PW1192_Planning Statement - March 2022.
Supporting Statement for Prior Approval Application for
Conversion of Agricultural Barns to Residential at
Elm Farm, Somersham Road, Little Blakenham

A Class Q application was submitted in December 2021 (ref: DC/21/06654/PN3), but was subsequently withdrawn due to a number of concerns that were raised during the consultation process. All of the concerns have been addressed as follows:

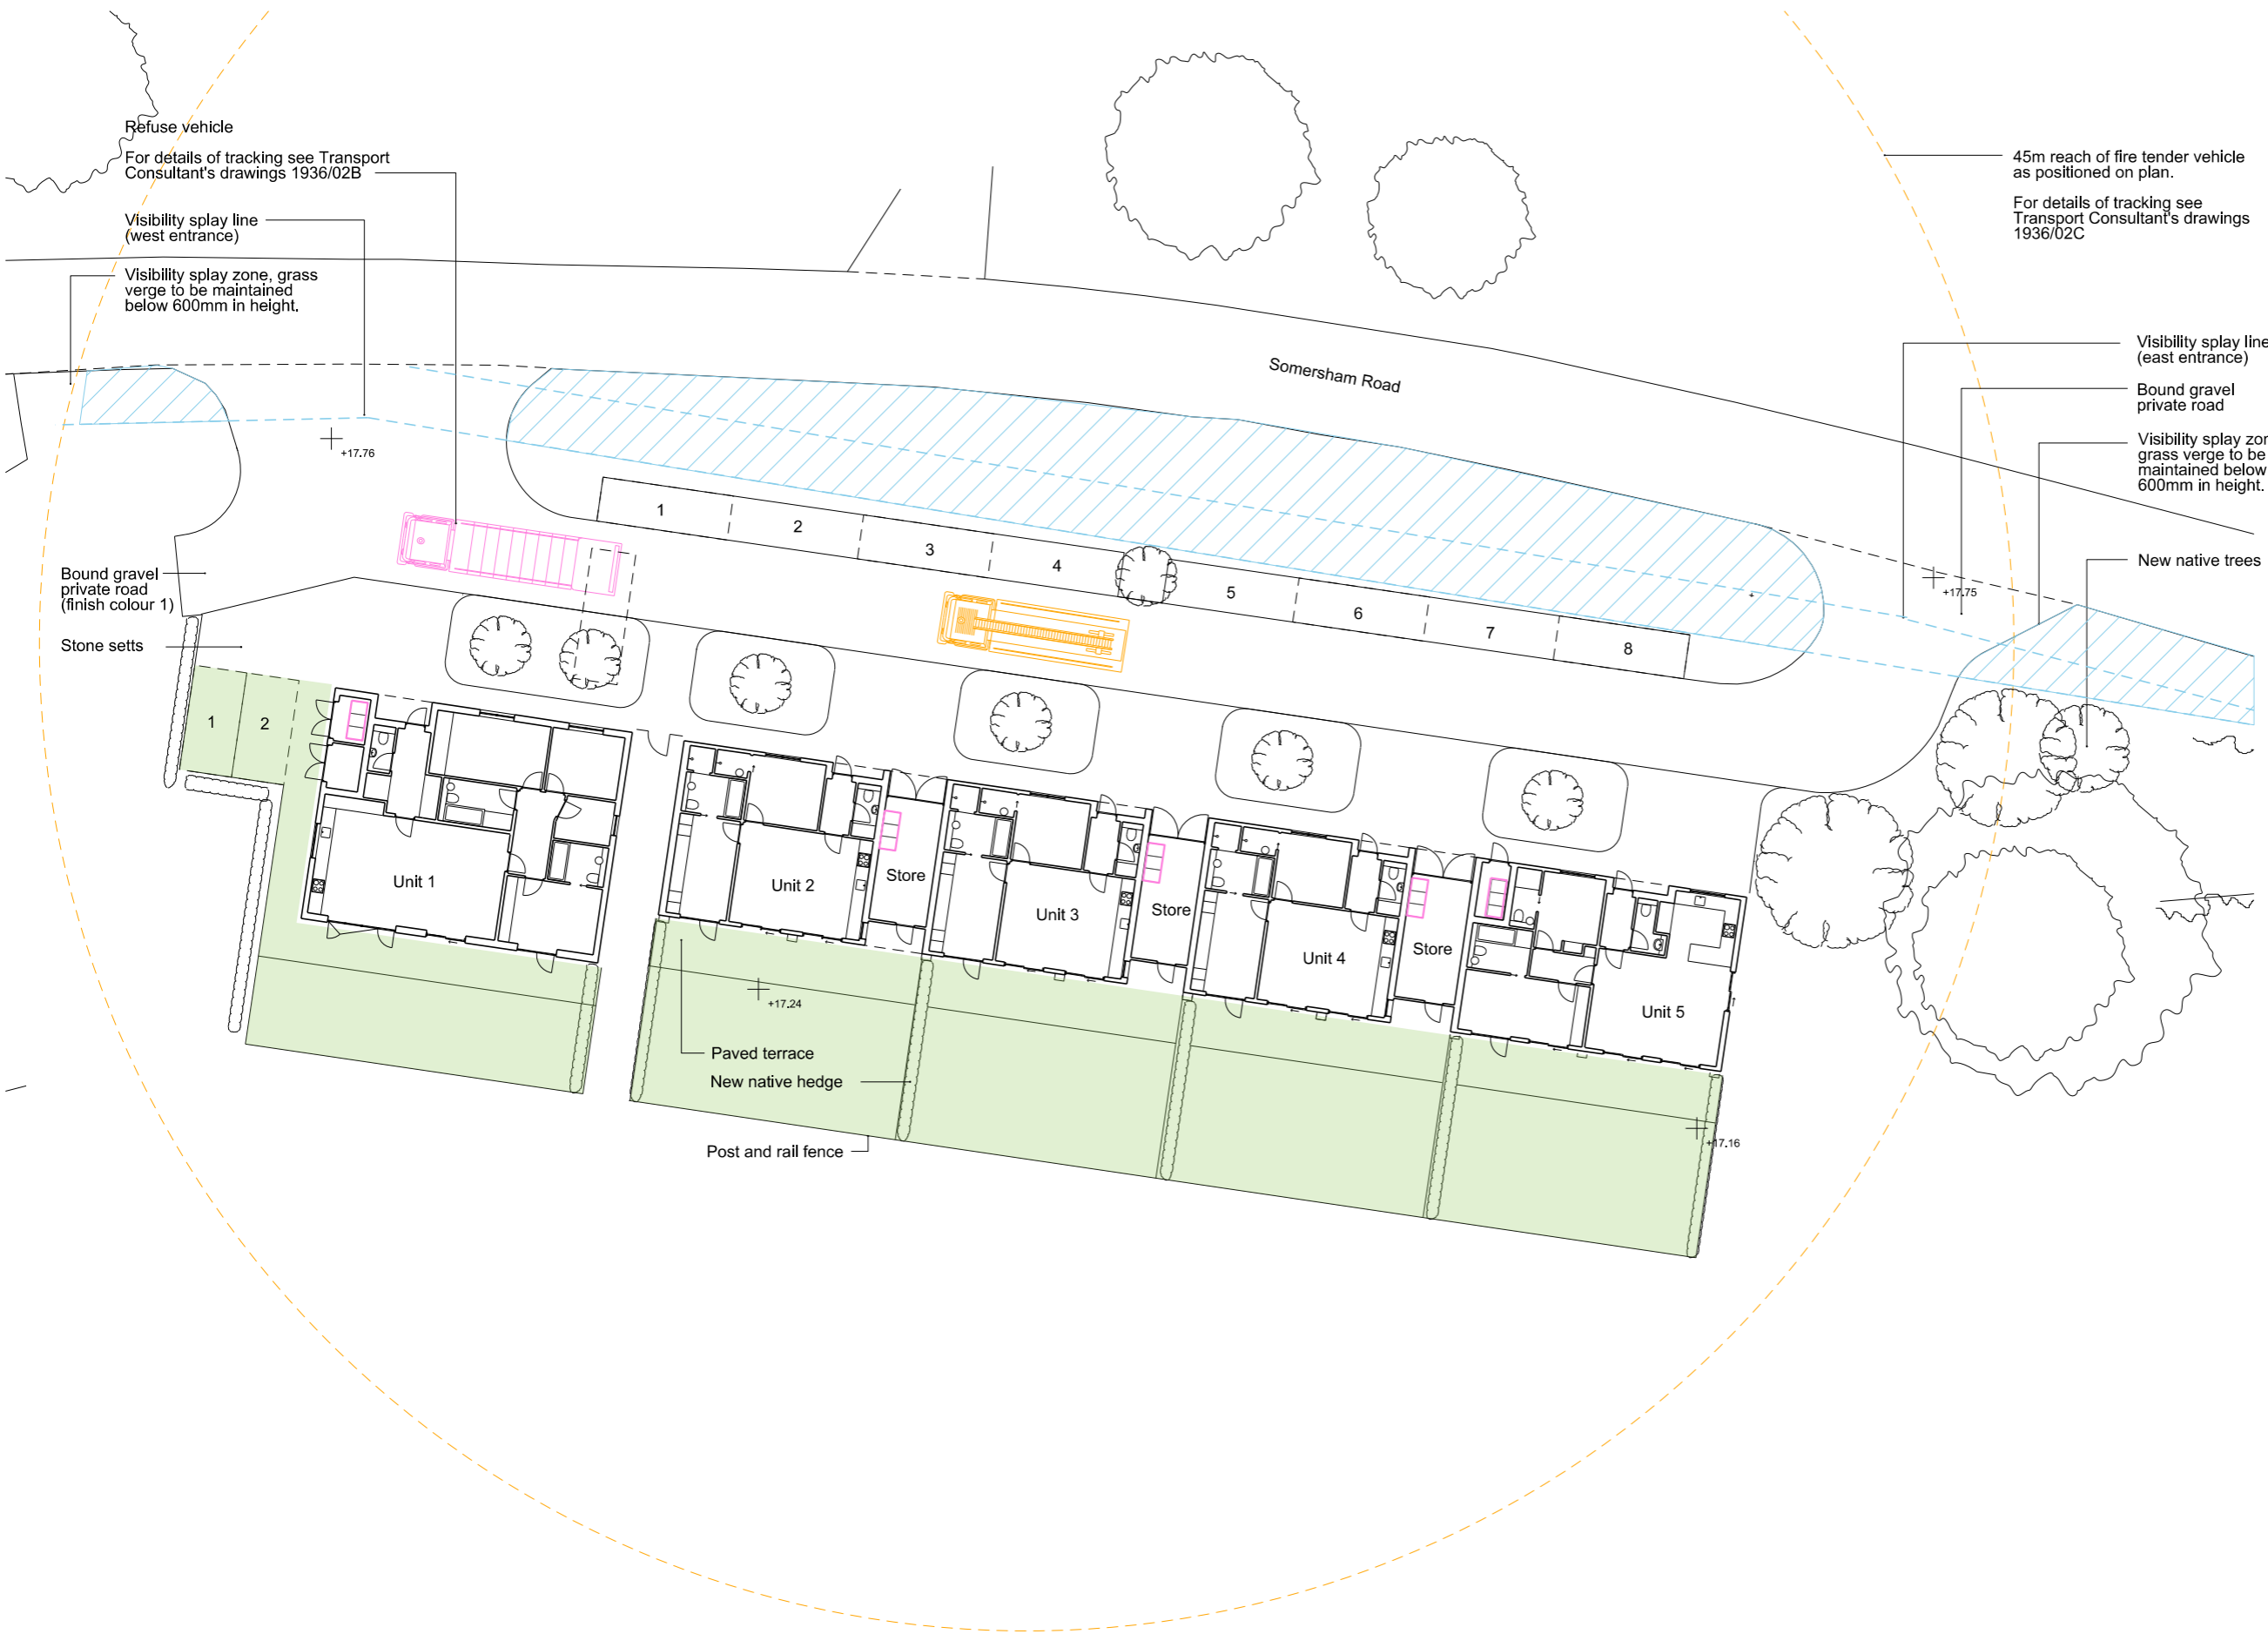
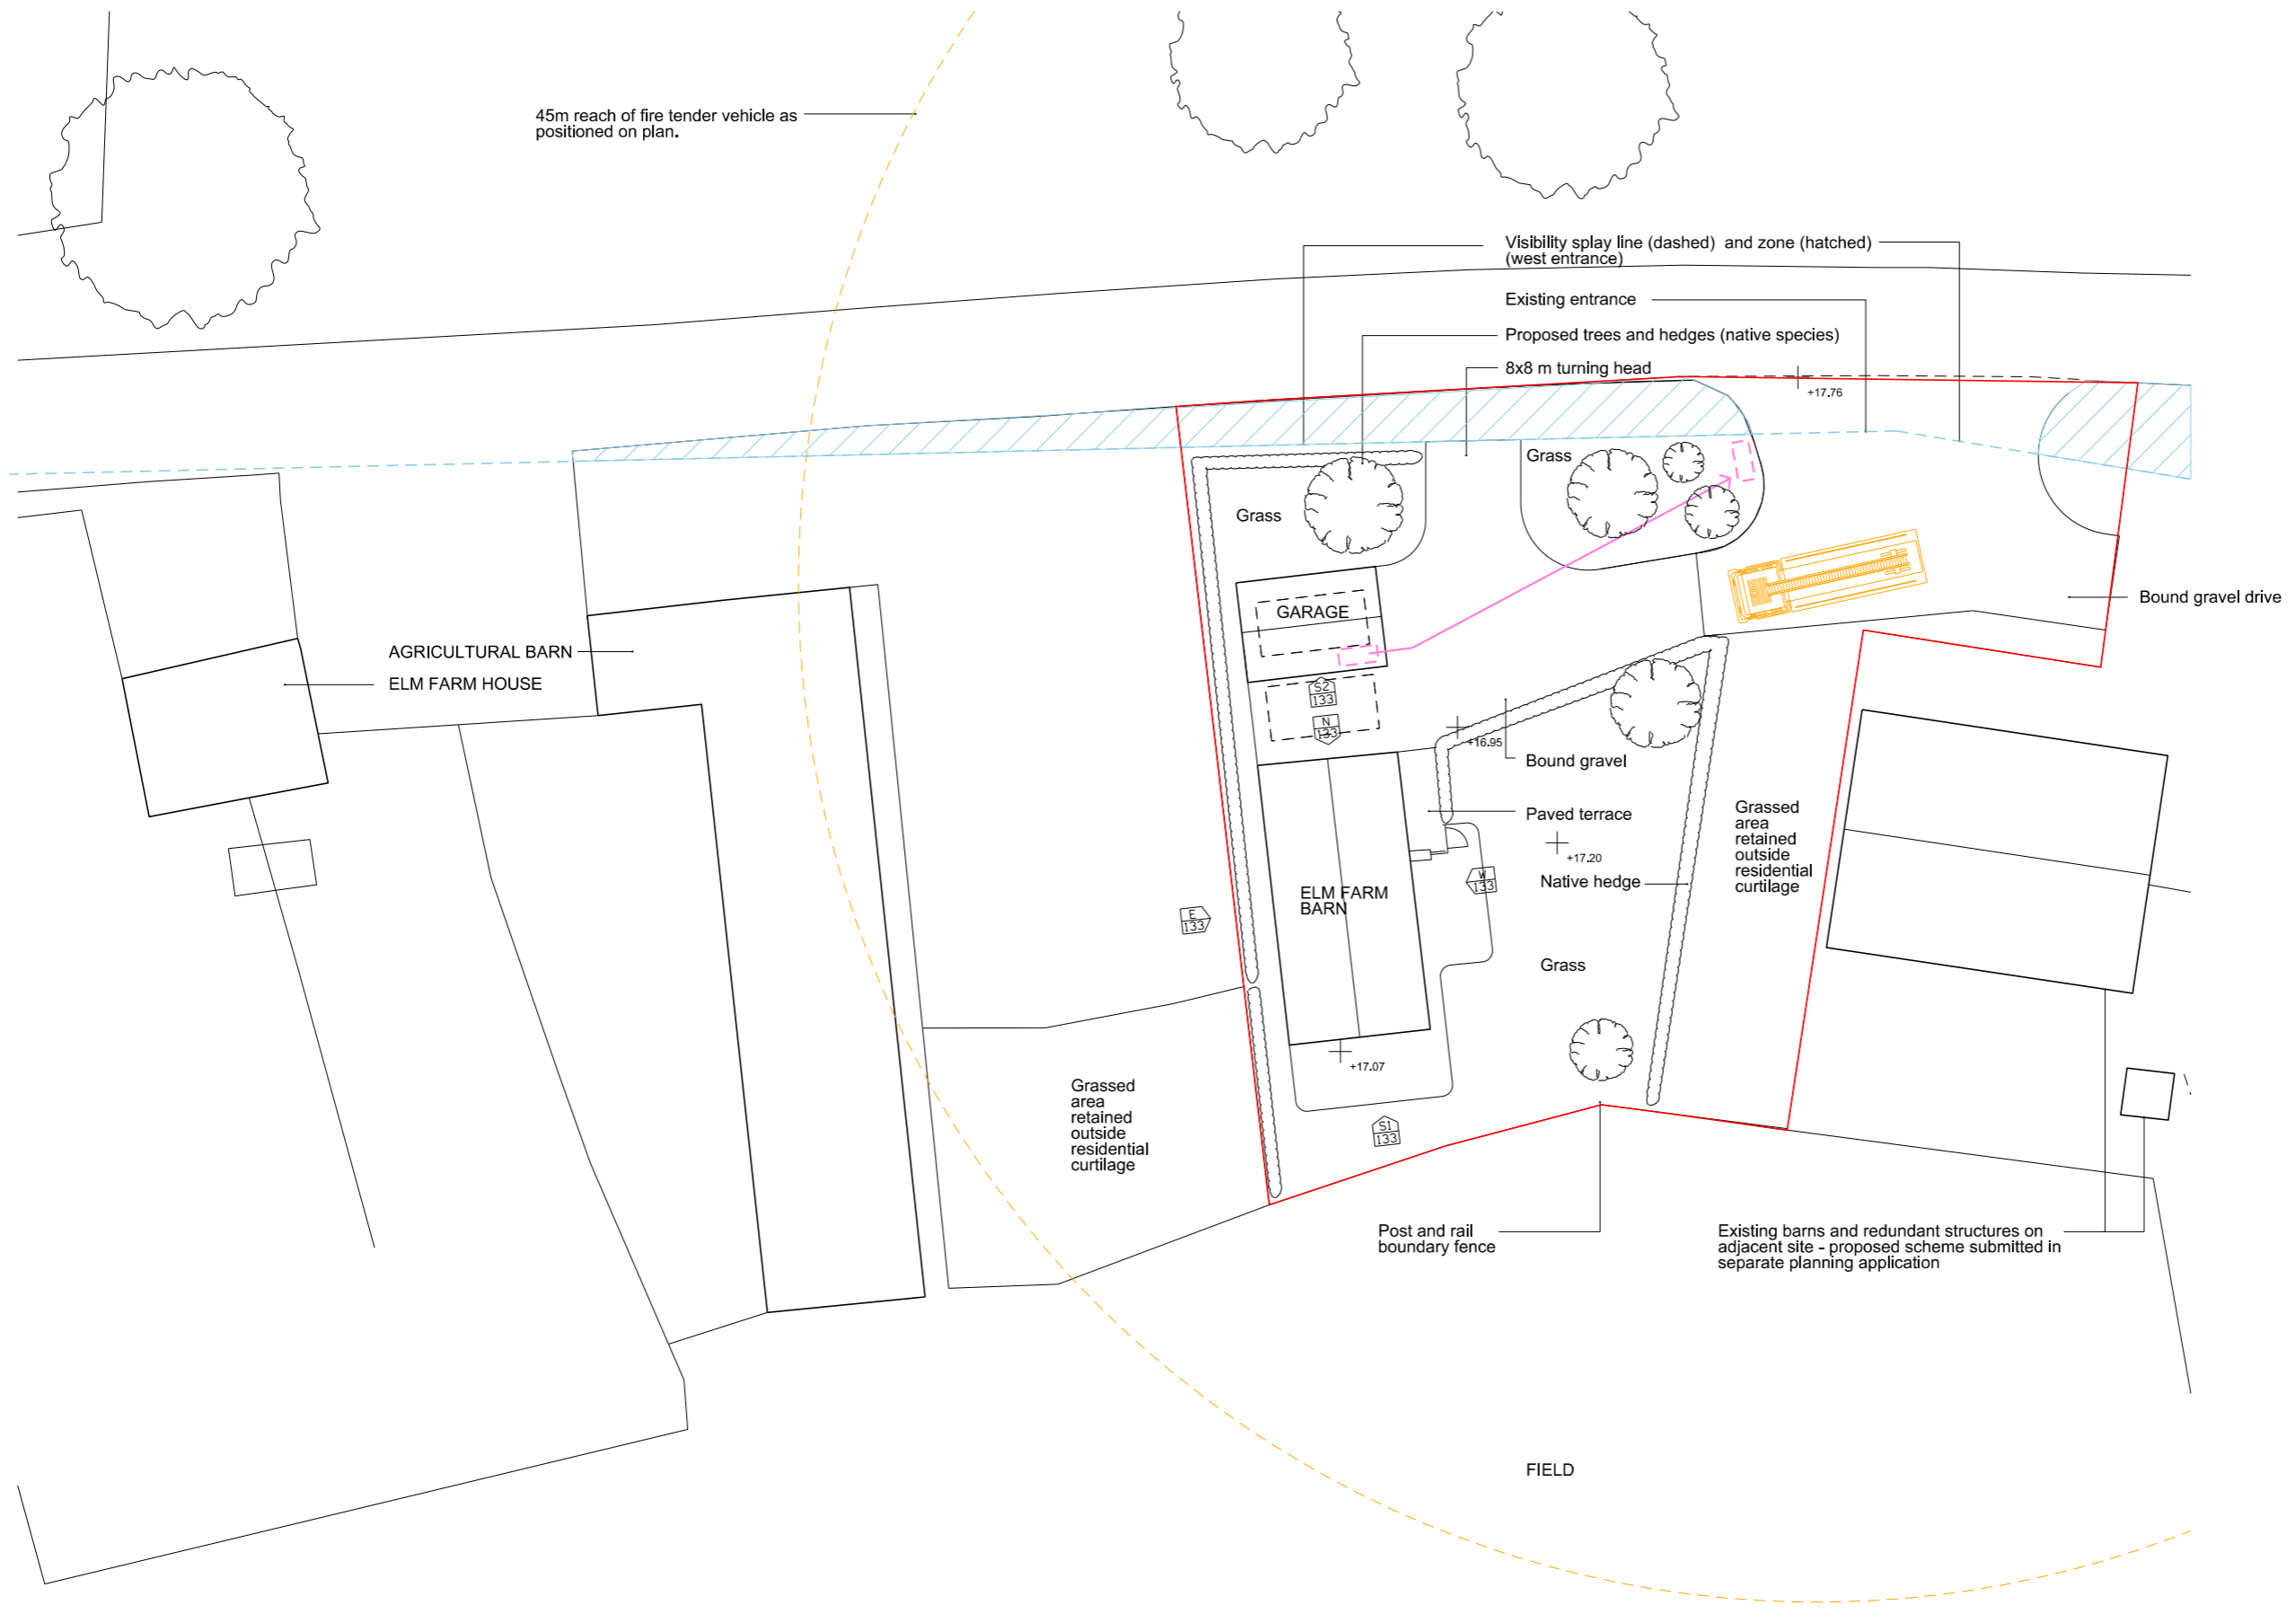
- *“I would note that it would be very useful to submit a proposed site plan similar to that provided on the previous submission”*.

- *“For Suffolk County Council to determine the application, visibility splays should be provided to determine the level of visibility the proposed access would be able to achieve”*.

- *“Any new access in this location would need to be designed in accordance with Suffolk County Council's Standard Access Drawing No. DM01”*.

- *“Areas have been allocated for bin storage; however, no location has been assigned for presentation. Drawing to be revised with allocated areas for bin presentation on site”*.

We now include a proposed site plan layout, which indicates each of the dwelling curtilages and parking areas.

We have added visibility splays to the proposed site plan drawing PL204. These are based on the traffic surveys included with the original approved scheme, that we are also enclosing with this application.

A note has been added to the site plan drawing PL204 to cover this.

We have added bin storage area and presentation points on the site plan drawing PL204.
